Application No: AW/3/21/HH
Site Address: 4 Shorecroft Aldwick PO21 4AS
Description of works: Single storey rear extension and loft conversion with enlarged rear dormer window and two modest front facing dormer windows. Alterations to fenestration, Canopy to side elevation, Planter and replacement handrail to roof terrace.

Thank you for your internet representation made on 7th February 2021 which has been recorded as an objection with the comments as follows:

NORTH ELEVATION

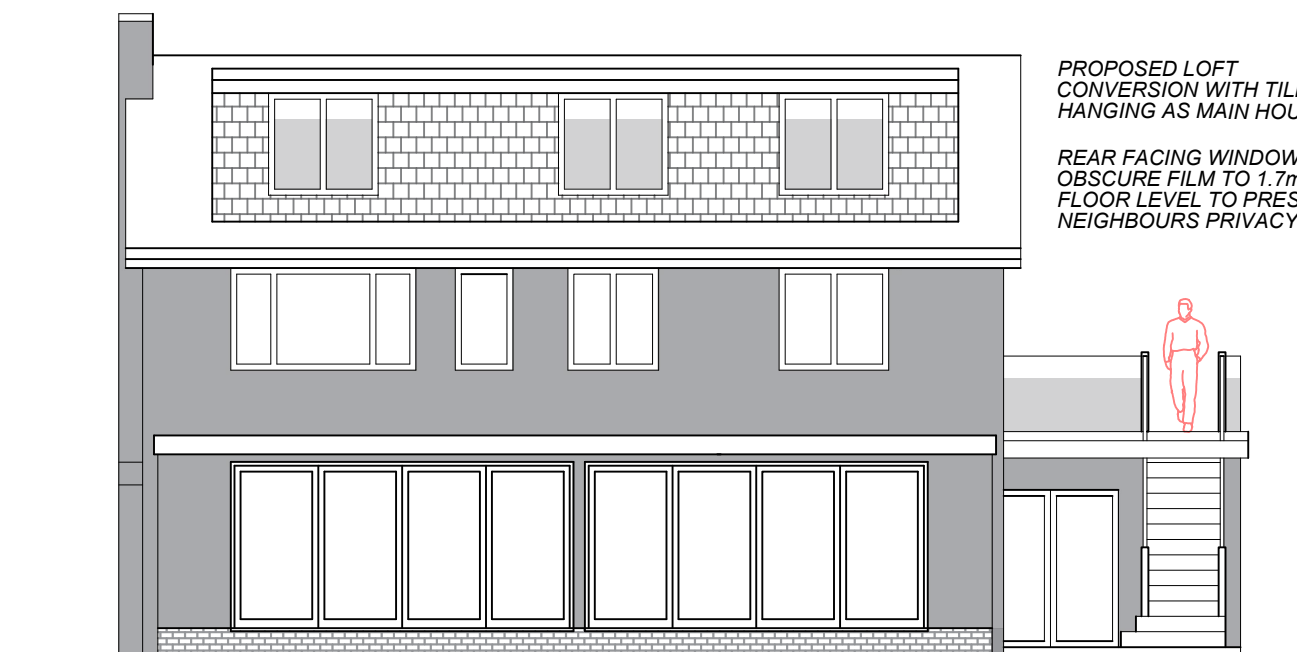
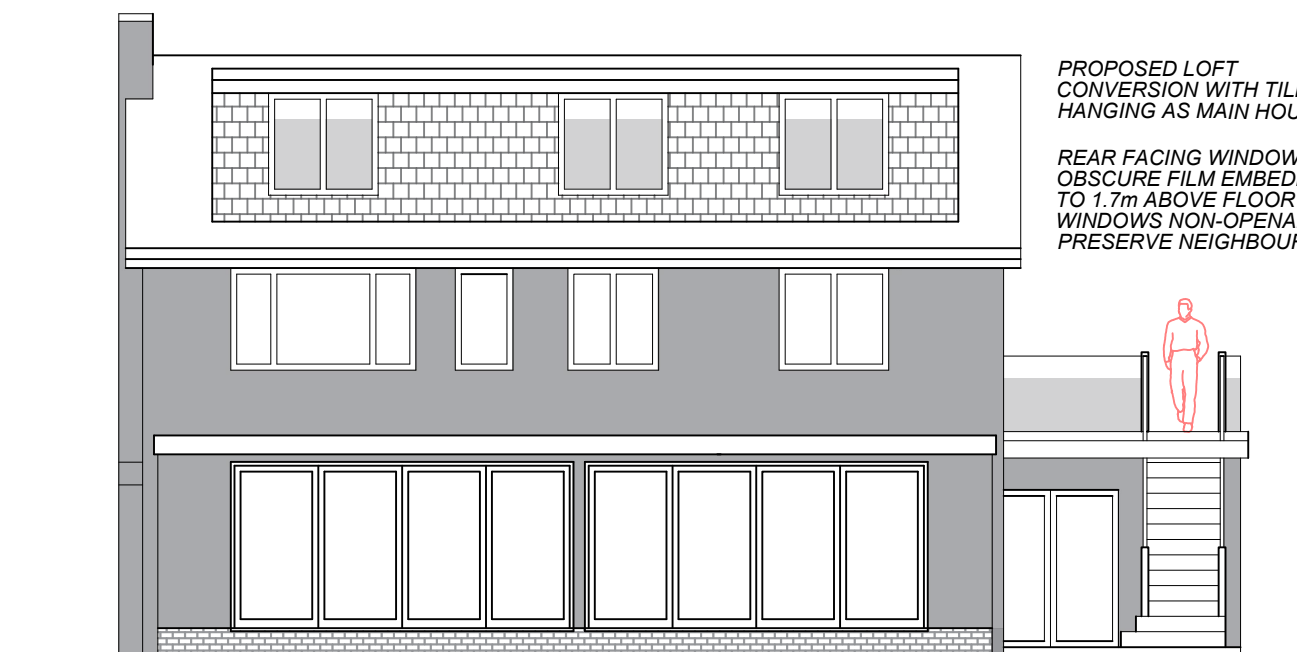
By permitting the oversize north facing dormer ADC will destroy that which has been carefully preserved over the past fifty years.

There are no objections to the ground floor extension, but the loft conversion is out of scale and appearance with other estate properties. It is overbearing and out of proportion with the existing properties and will create a domineering eyesore from many viewpoints on the estate.

The privacy of overlooked properties will be lost causing distress and anxiety to residents affected. The owners of 4 Shorecroft have previously refused to install Velux rooflights in line with the roof slope and so the only permanent solution to this is to apply a condition that all north facing windows of the loft conversion must be permanently fitted with obscured glass and be non-opening.
